May 15, 2020

**SUBJECT: Insurance Auto Auction – Initial Review Comments
Development Plan (AR DP 19-00601; Final Plat (AR FP 19-00602)**

Please see the following responses to City review comments in ***bold and italics*** for the initial review of Insurance Auto Auctions.

C1.4

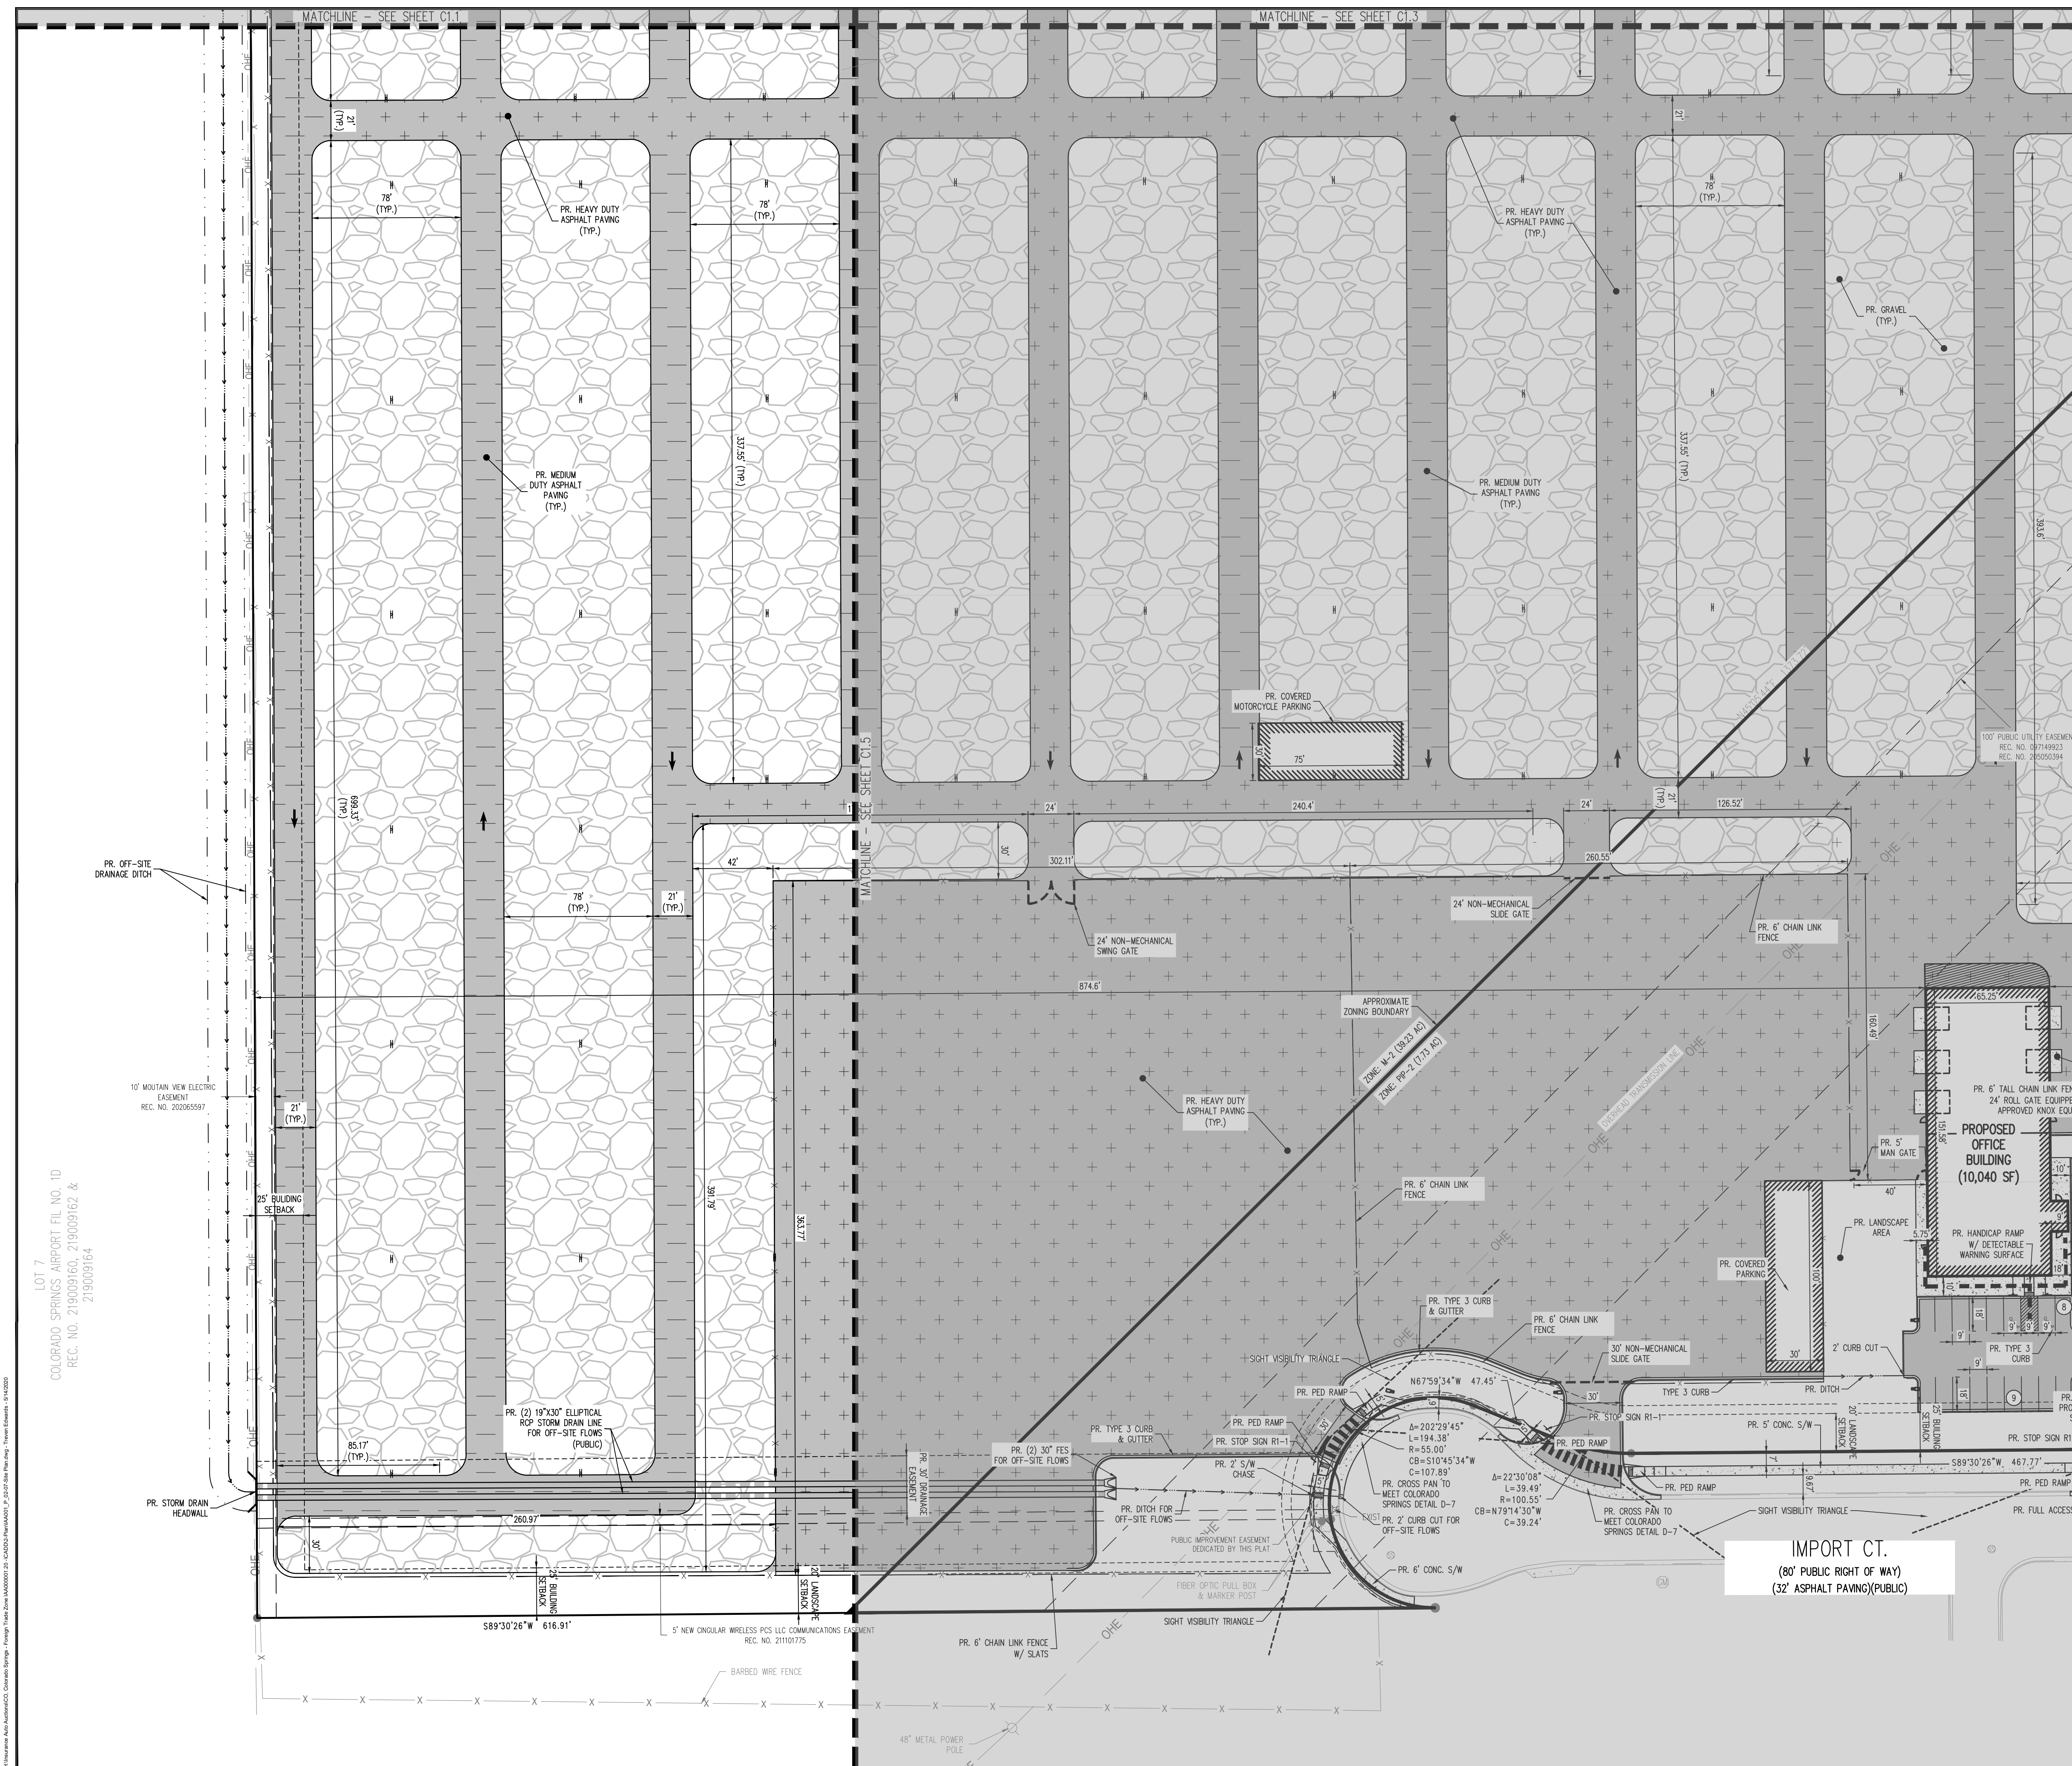
1. Show and callout 5' wide detached sidewalk with a 7' tree lawn area or 6' wide attached sidewalk adjacent to the platted lot along Import Court and Foreign Trade Zone Boulevard. Add a pedestrian ramp that crosses Import Court at the intersection of Import Court and Foreign Trade Zone Boulevard and at each access.

1. DISAPPROVED COMMENTS: Indicate on the plans the gate(s) will be equipped with approved Knox equipment.

Response: A 5' wide detached sidewalk with a 7' tree lawn area has been provided along Import Court and a 6' wide attached sidewalk has been provided along Foreign Trade Zone Boulevard (FTZ), as requested. The grading functioned better with the attached walk along FTZ Blvd.

Response: The gate(s) will be equipped with approved Knox equipment and a callout has been added to the site plan, as requested.
